Consultation Response from: KC Environmental Health (Pollution & Noise Control)		
2021/91946 - Brenntag UK Ltd, Union Mills, Oxford Road, Gomersal, Cleckheaton, BD19 4JW		
Discharge of conditions 4, 5, 6, 7 & 8 on previous permission no. 2019/93797 for erection of extension to existing warehouse and formation of new car park		
Date Responded: 16th August 2021	Responding Officer: Natalie Heaney	Responding Ref: WK/202119615
Conditions 4, 5, 6 are outside the remit of Environmental Health. Condition 7 – Unexpected Contamination Condition 7 concerns the finding of any contamination encountered during the development that has not previously been identified by the developer prior to planning permission being granted. To discharge Condition 7, a supporting statement has been provided titled ‘<i>FAO Kirklees Council,</i>’ by HB Projects Ltd dated 10th May 2021 (no reference). Under Condition 7 it is indicated in the document that ‘<i>WAC tests were undertaken with no contamination present.</i>’ We acknowledge that in the previously assessed Roberts Environmental Ltd Geo-Environmental Assessment Report dated October 2019 (ref: 190811.R.001) Waste Acceptable Criteria (WAC) testing had been c

P21-3278-00-01

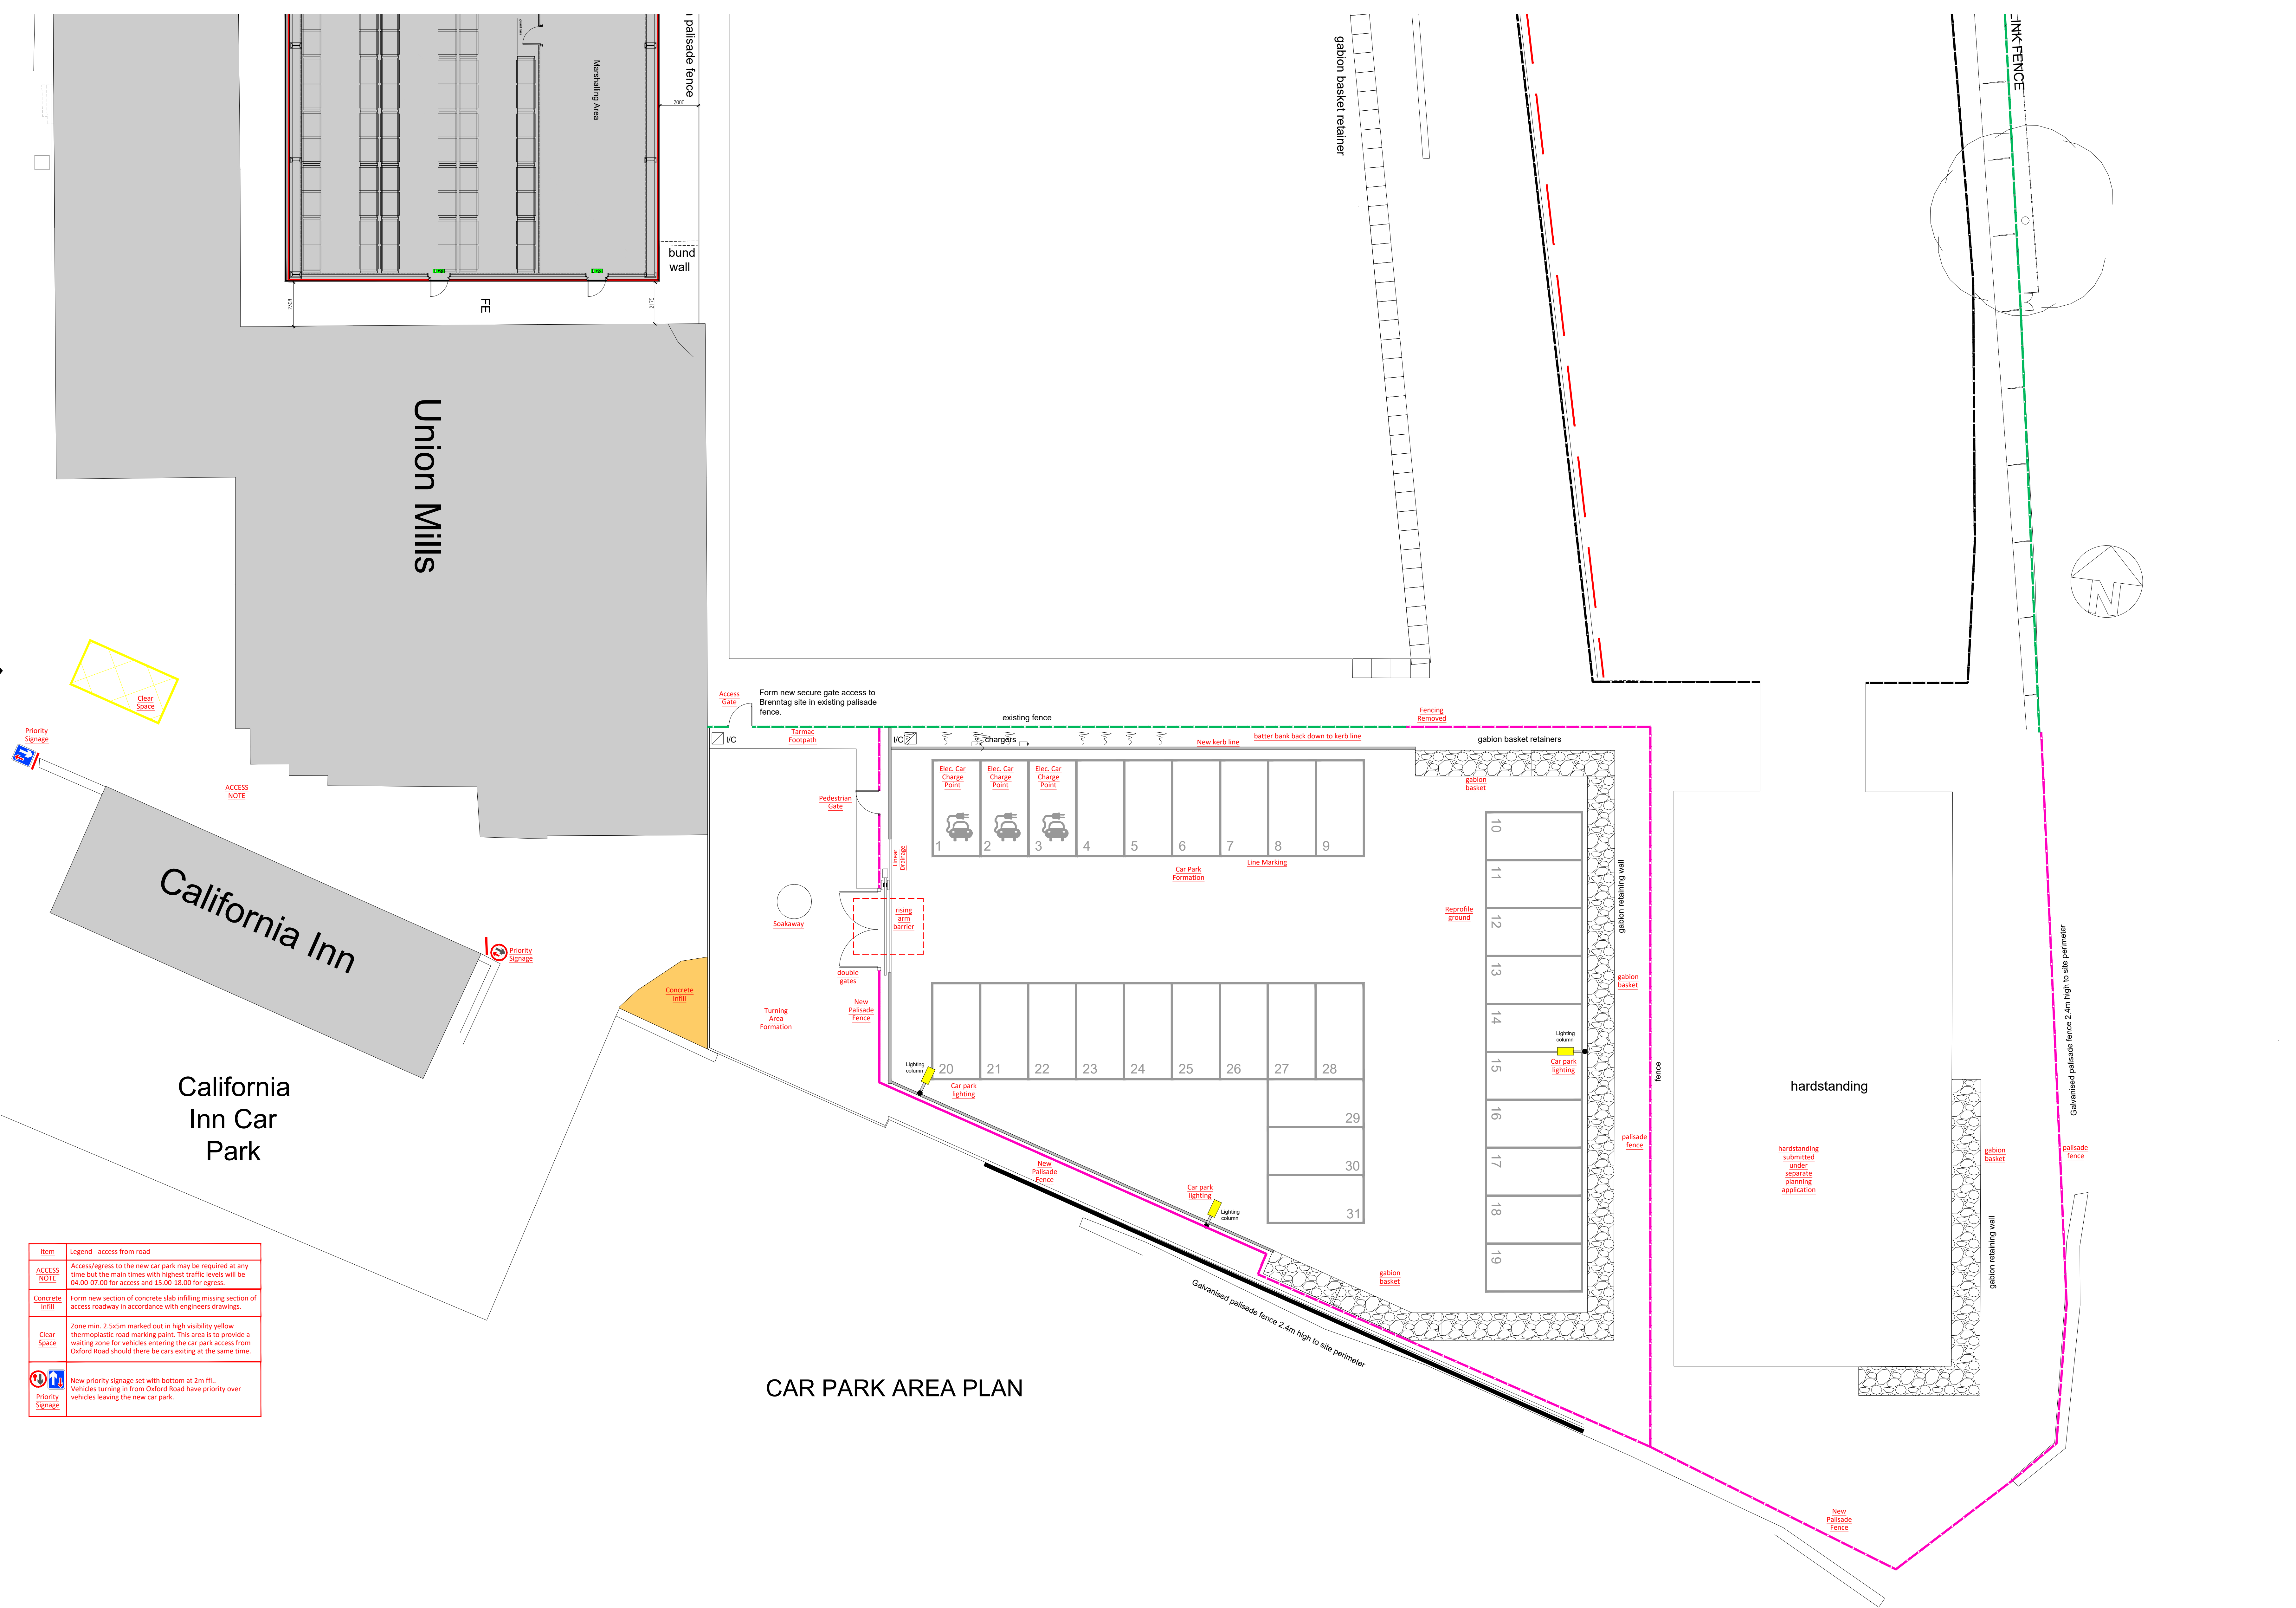
specification - Electric Vehicle Homecharge Scheme (EVHS)" by the Office for Low Emission Vehicles. Charging points that provide Mode 3 charging with a continuous output of least 16A (3.5kW) and have a Type 2 socket outlet would be acceptable.

For that reason, the information provided about electric vehicle charging points is considered unacceptable at this stage, so we recommend that Condition 8 remains. Further information concerning the charging point specification is necessary.

For that reason, the information provided about electric vehicle charging points is considered unacceptable at this stage, so we recommend that Condition 8 remains. Information concerning the charging point specification is required.
